# ***City of Albuquerque***

**RE: QUANZ CAR CARE FACILITY (C-12/D5A)**  
**(9101 Eagle Ranch Rd NW)**  
**ENGINEERS CERTIFICATION FOR CERTIFICATE OF OCCUPANCY**  
**ENGINEERS STAMP DATED 8/8/2001**  
**ENGINEERS CERTIFICATION DATED 7/5/2002 Rev. 8/1/2002**

***RE: QUANZ CAR CARE (C12-D5A). GRADING AND DRAINAGE PLAN FOR  
FOUNDATION PERMIT, BUILDING PERMIT AND SO#19 PERMIT  
APPROVALS. ENGINEER'S STAMP DATED AUGUST 8, 2001.***

#### A PROPOSED GRADING AND DRAINAGE PLAN

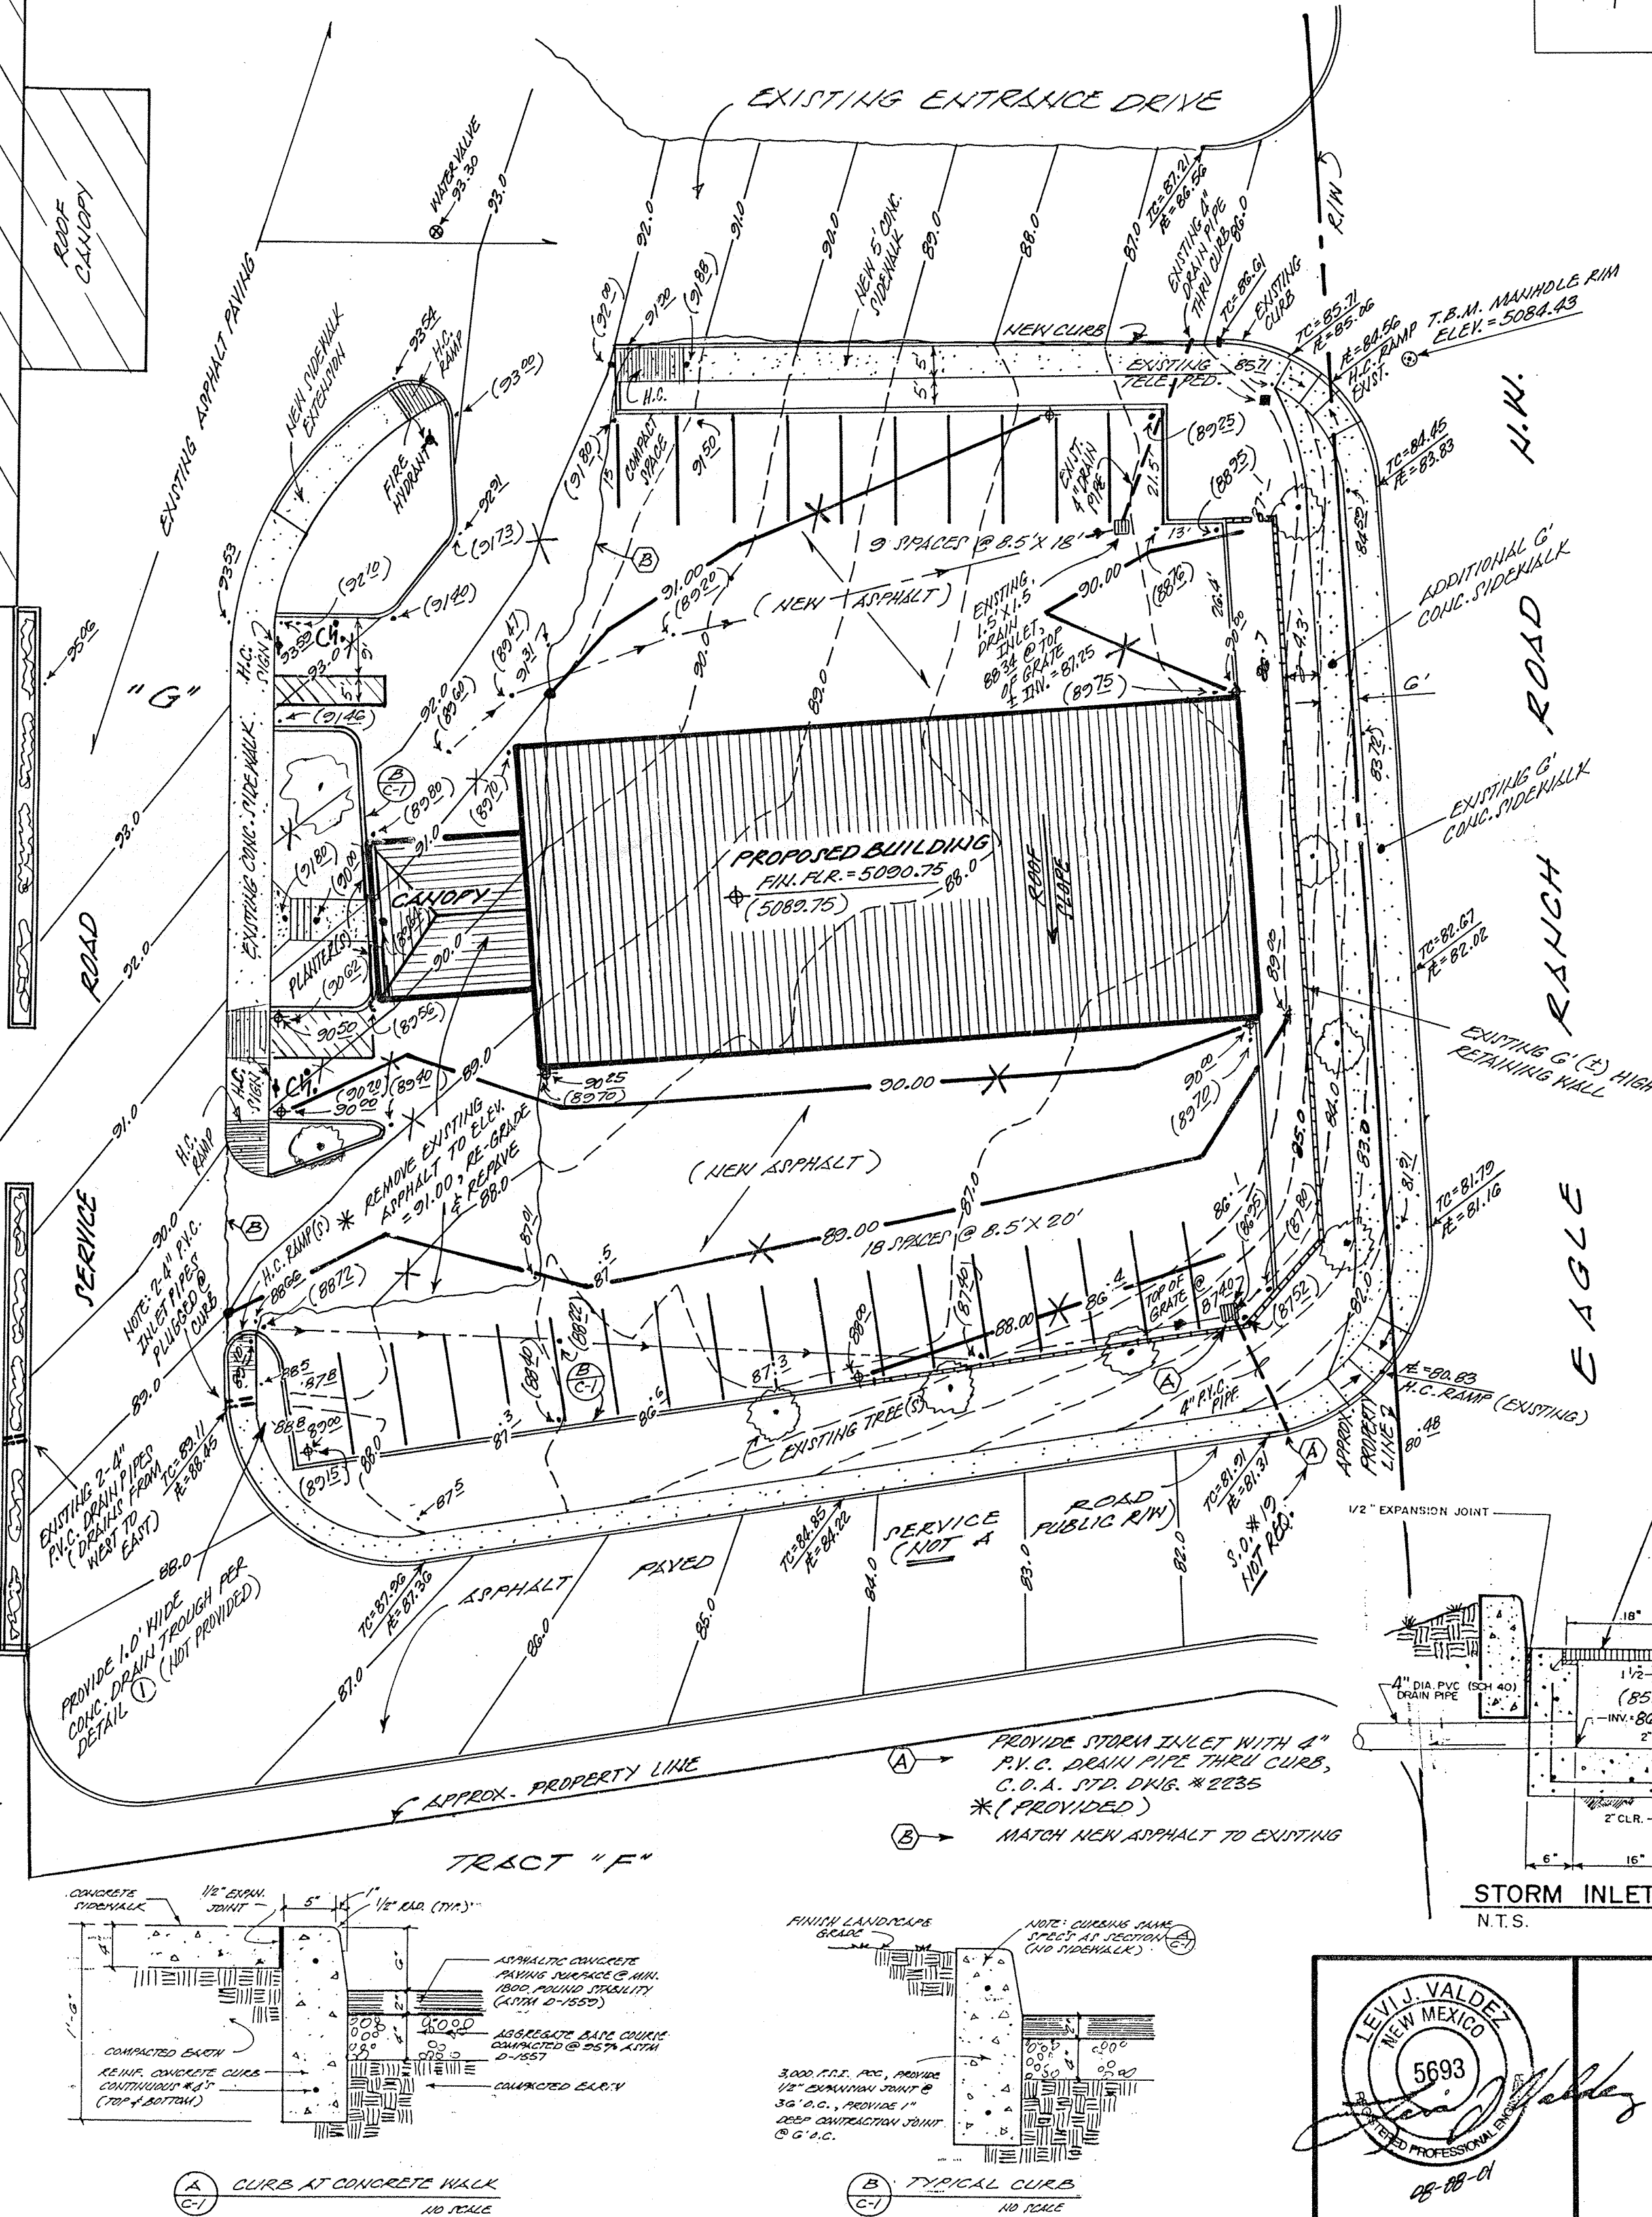
\*\*\* Remove the word "Proposed" from the Title Block. This is the approved G & D Plan.
